## Department of Transportation

Traffic & Safety - Permits Unit

RE: Hillpointe Apartments (PPR2613)

SECONDARY ACCESS FROM PETERSON ROAD

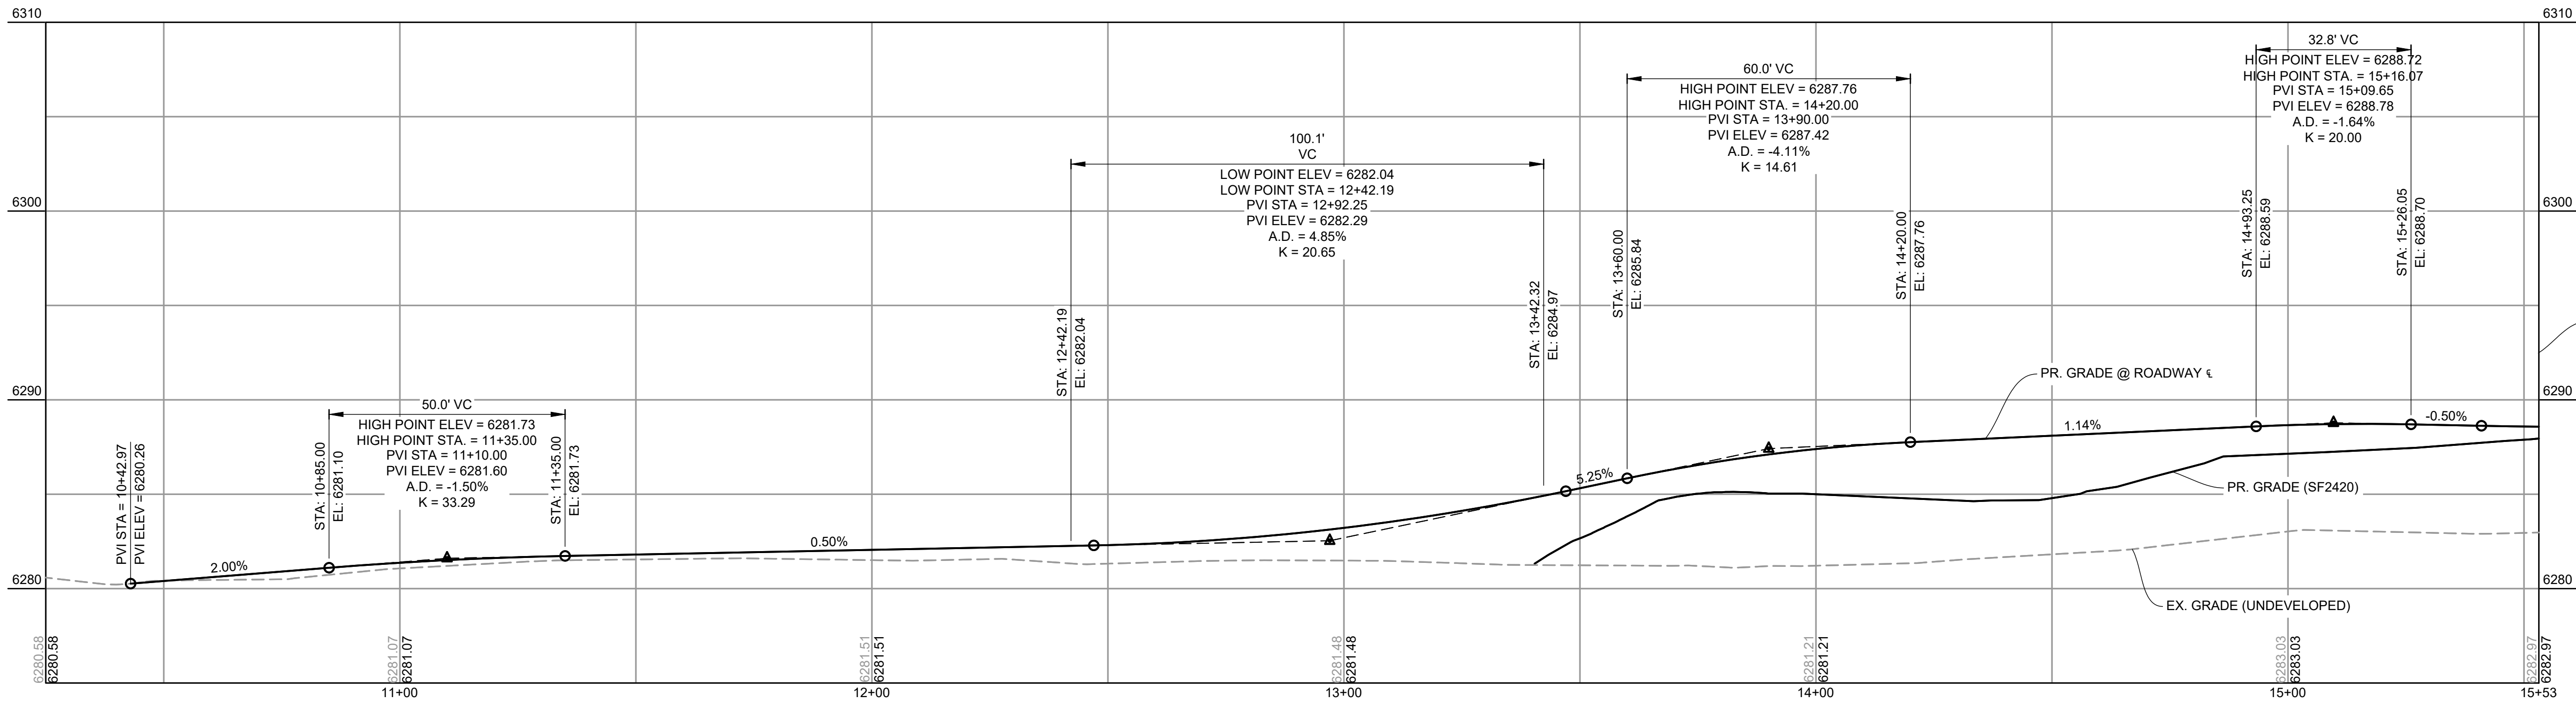
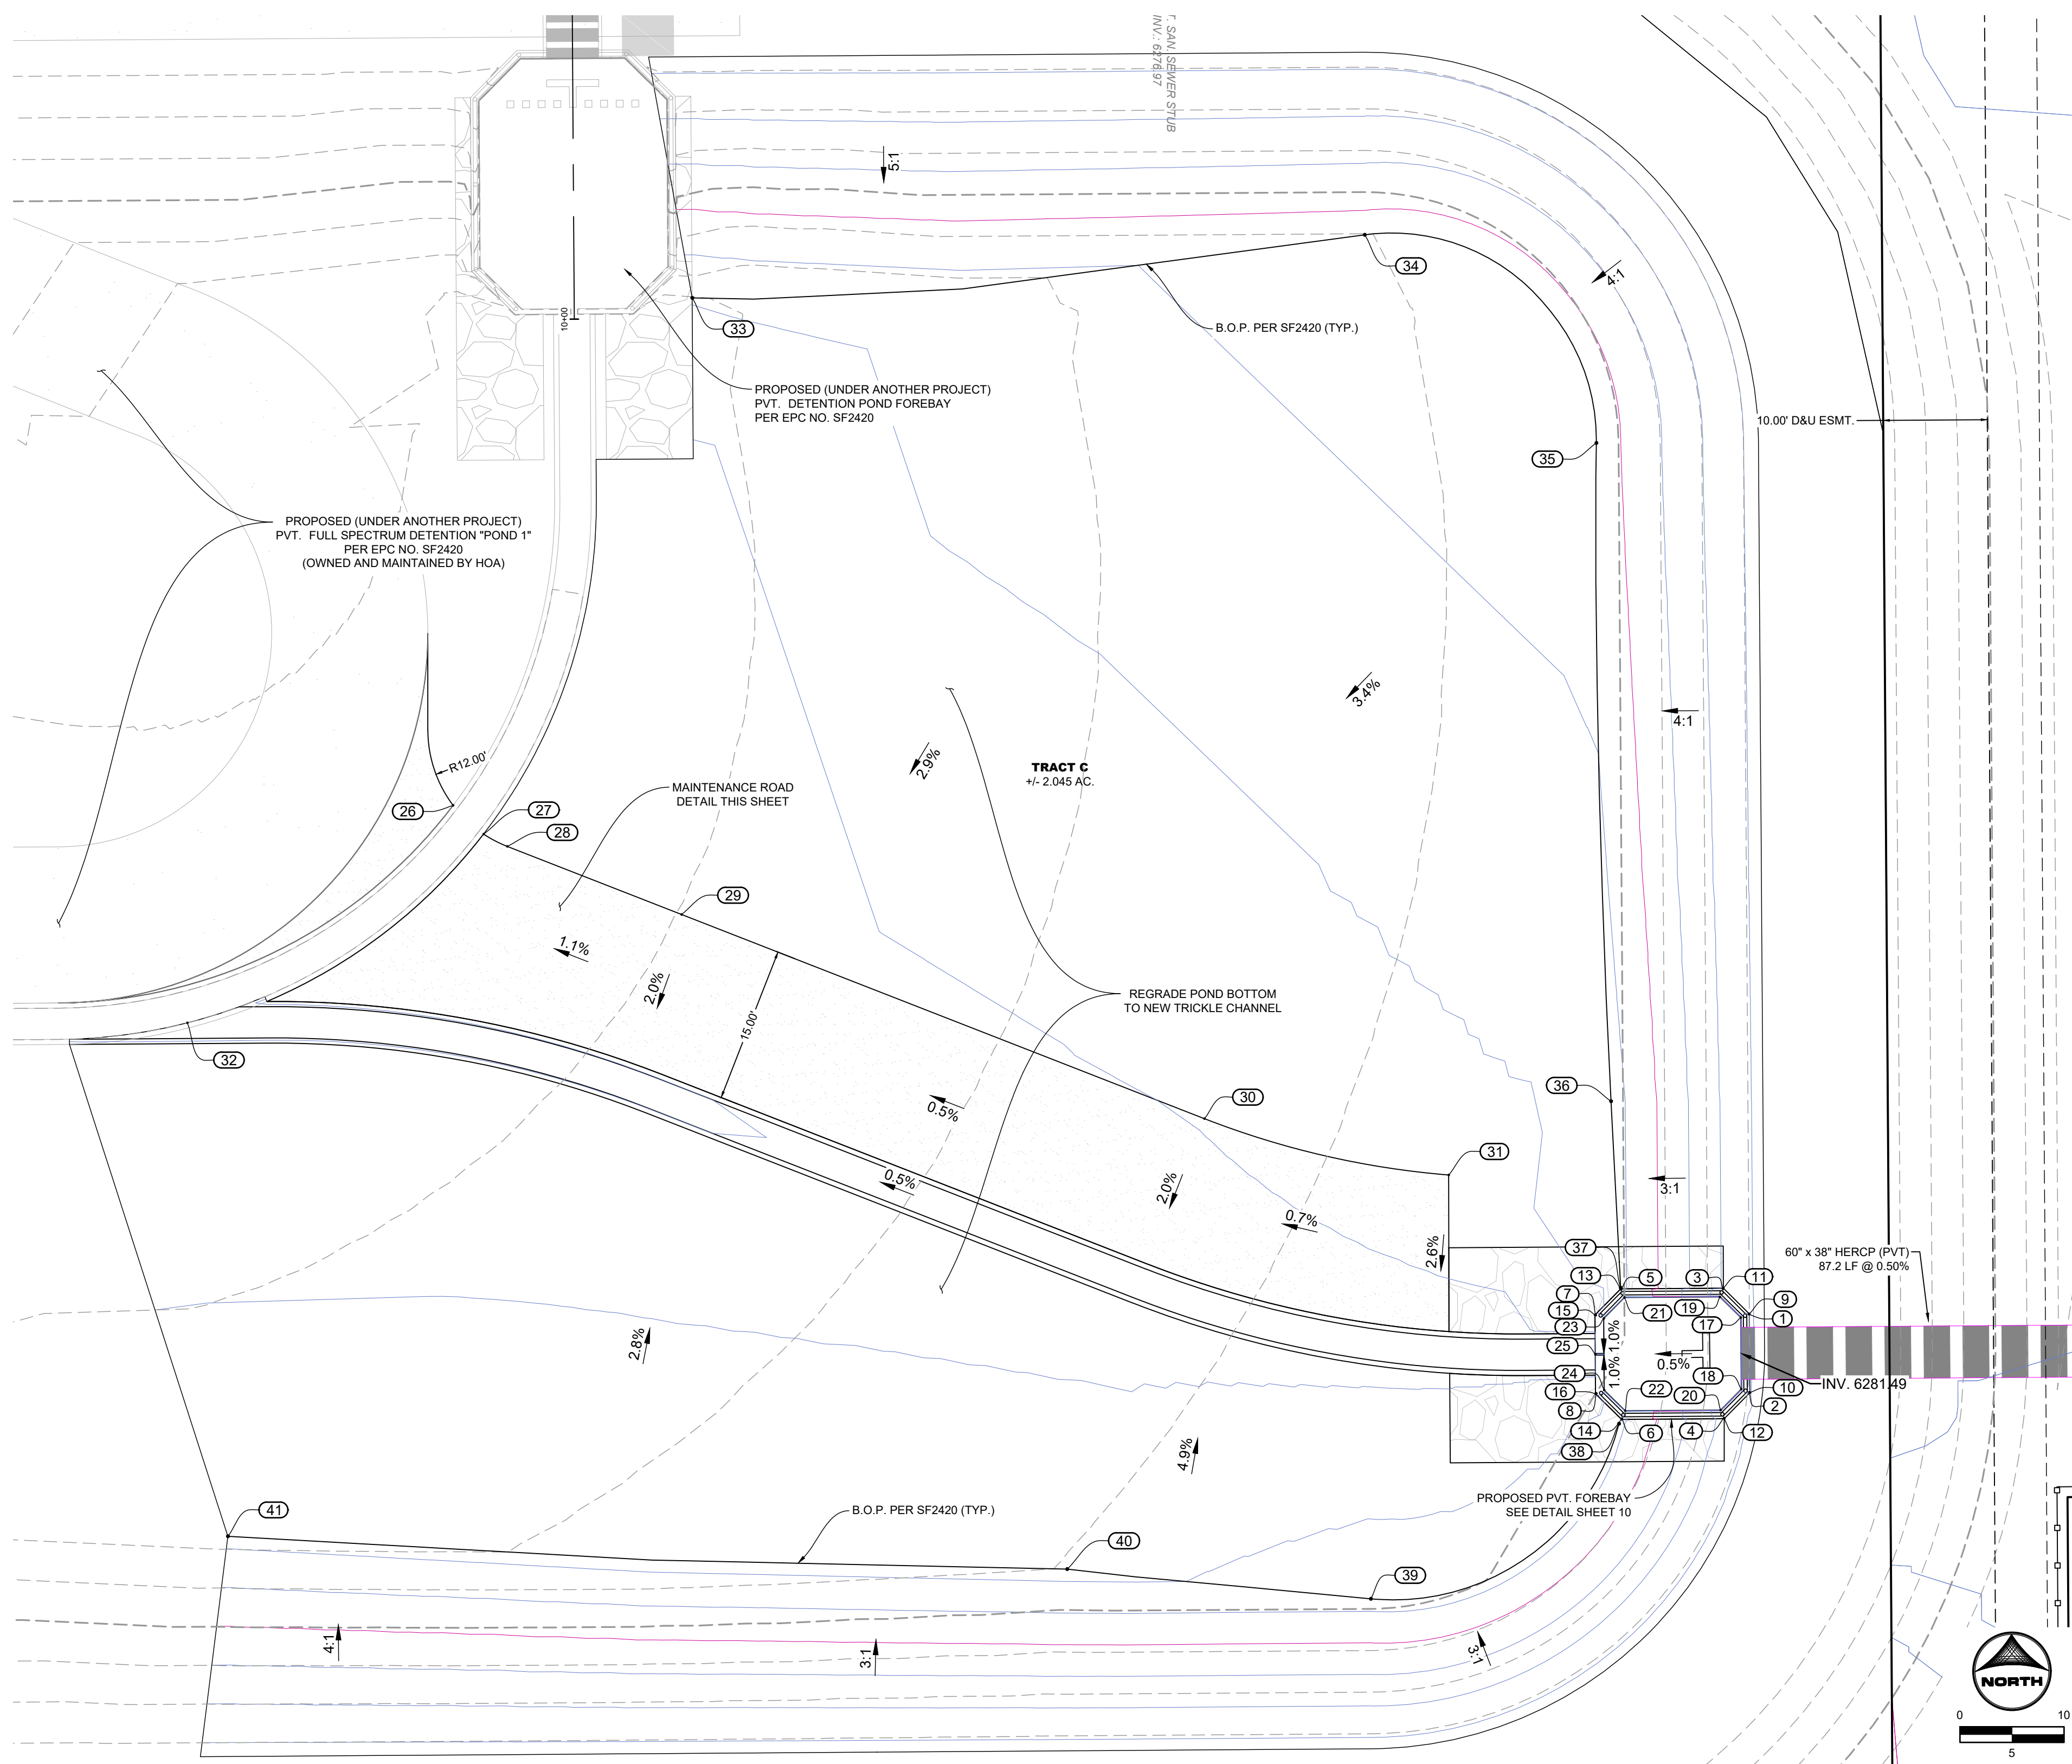
- Roundabouts are being constructed at US-24G (E Platte Avenue) and Peterson Blvd which will improve interchange operations. The existing access is  $\pm 275$  feet north of the off-ramp terminal from US-24G. The existing cross-over at Panamint Court shall be eliminated and median constructed across.

- The Traffic Impact Study for "Hillpointe Apartments at Peterson" dated September 2025, revised May 2026 states:  
"Proposed access to the development is provided via one full-movement access onto the future extension of Meadowbrook Parkway (referred to as Site Access). This access is anticipated to be shared with the future adjacent Cimarron Hills development. Additionally, it is noted that the existing intersection of Peterson Road with Panamint Court will be converted to a right-in/right-out intersection and serve as an emergency-only access for the proposed development."

- A letter from Emergency Services requesting an emergency access at this location and the reason for the request has been received.
- A CDOT Access Permit will be *required* for this development, prior to the subdivision plat being recorded, to document the median opening closure at the existing cross-over at Panamint Court.

- The median closure to convert the existing access to right-in/right out will be a condition of the permit.
